Re: BusConnects Belfield/Blackrock to City Centre Core Bus Corridor Scheme
Co. Dublin

Case Number 313509.

UCD Ballsbridge to City Centre (Part of Belfield/Blackrock to City Centre Core Bus Corridor Scheme).

Observations of Jack McEvoy and Freeda McEvoy of 83 Nutley Lane, Donnybrook, D04V8Y1.

TYPICAL SECTION W-W  
NUTLEY LANE  
LOCATED ON GA SHEET 23  
DRAWING REF: BCIDC-ARP-GEO\_GA-1415\_XX\_01-DR-CR-0023

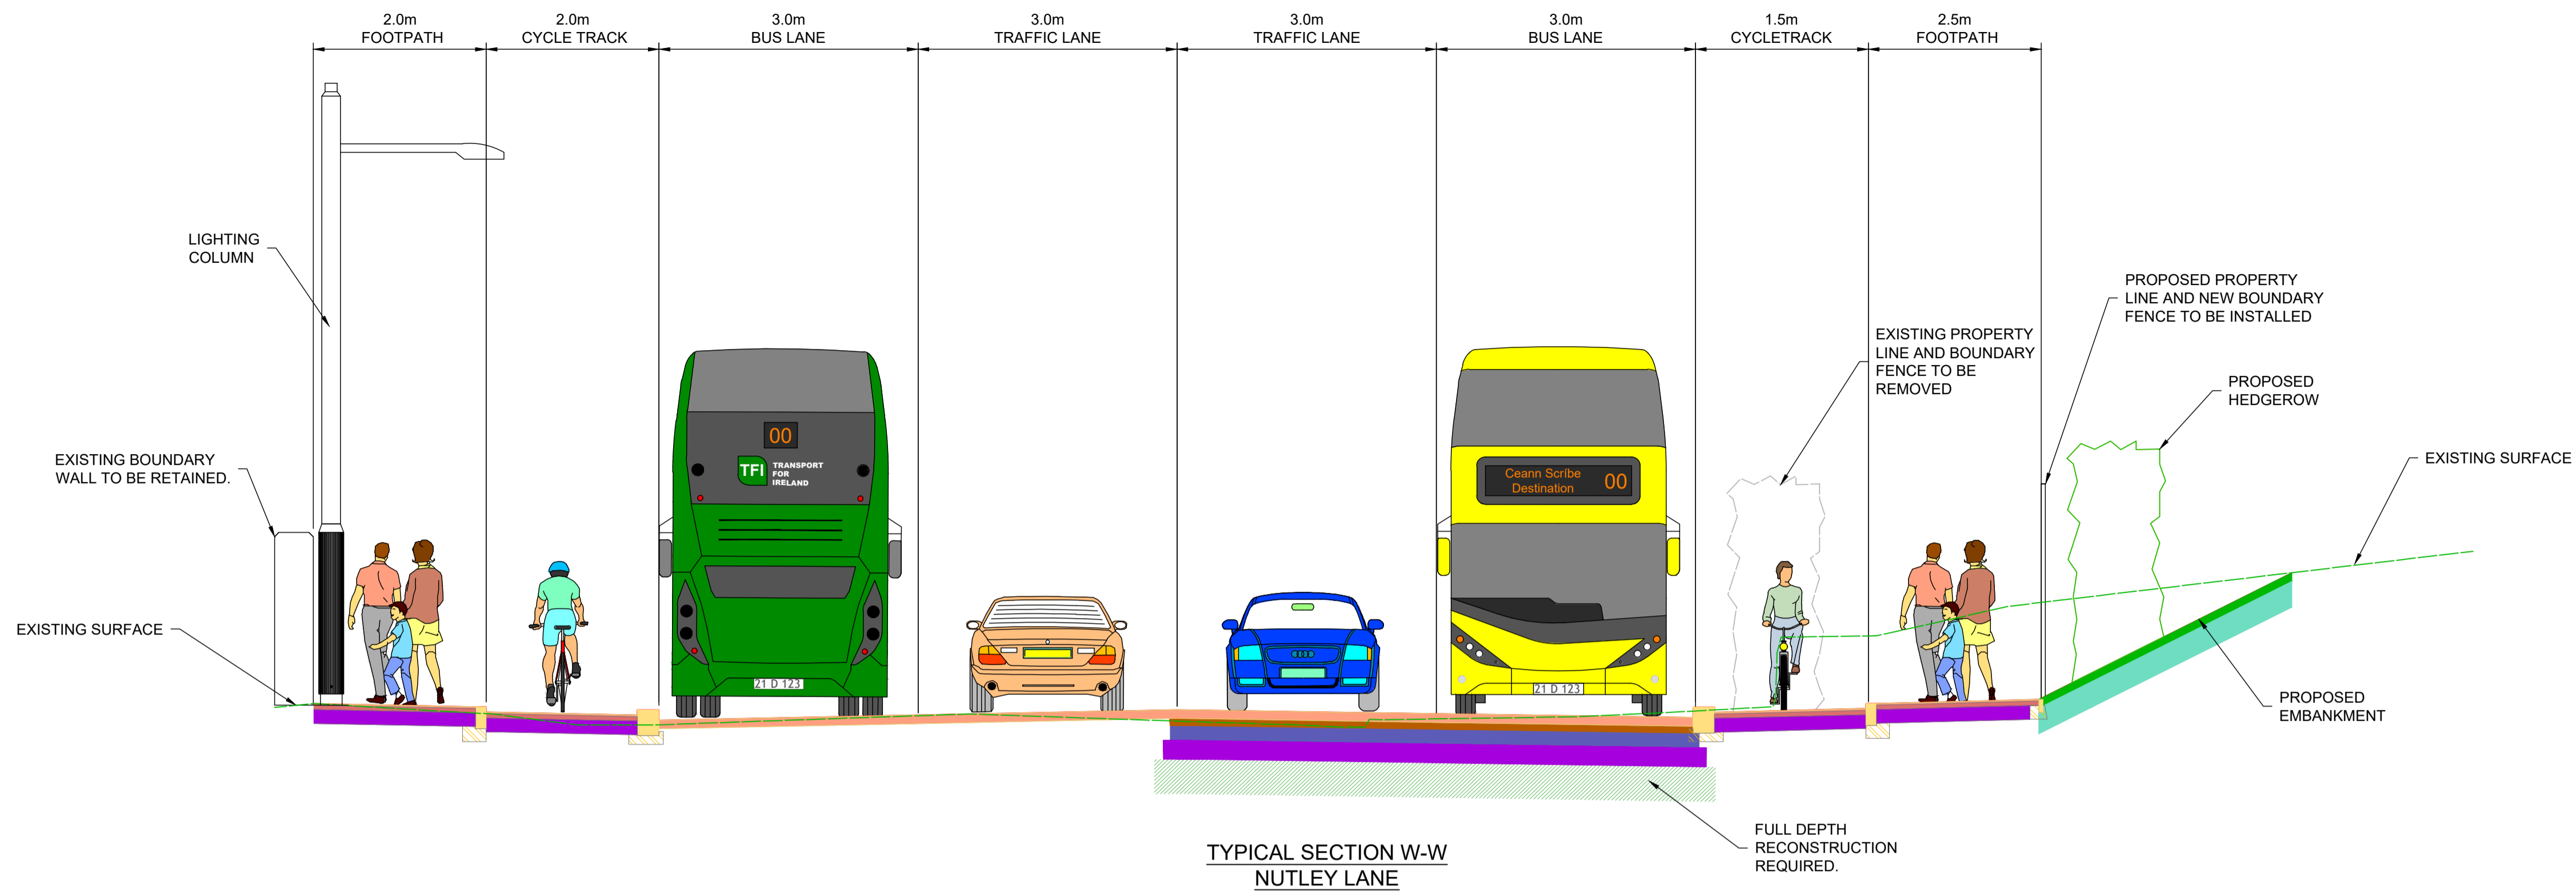
Option NL2 would remove over 80 mature trees and very significant hedgerows along the whole length of Nutley Lane from Merrion Rd to the top Nutley Lane. The hedgerow at St Vincent's Hospital is a beautiful beech hedgerow full of biodiversity. These mature trees and hedgerows remove Carbon Dioxide from the local environment and also act as buffers to reduce noise levels and vibrations.

The proposal in NL2 to replace the trees and hedgerow running along Elm Park Golf Club with a concrete wall will significantly increase noise and vibration levels and Carbon Dioxide emissions.

We recommend that the option NL2 be withdrawn and that the NTA consider the alternative options NL3 and NL4 .
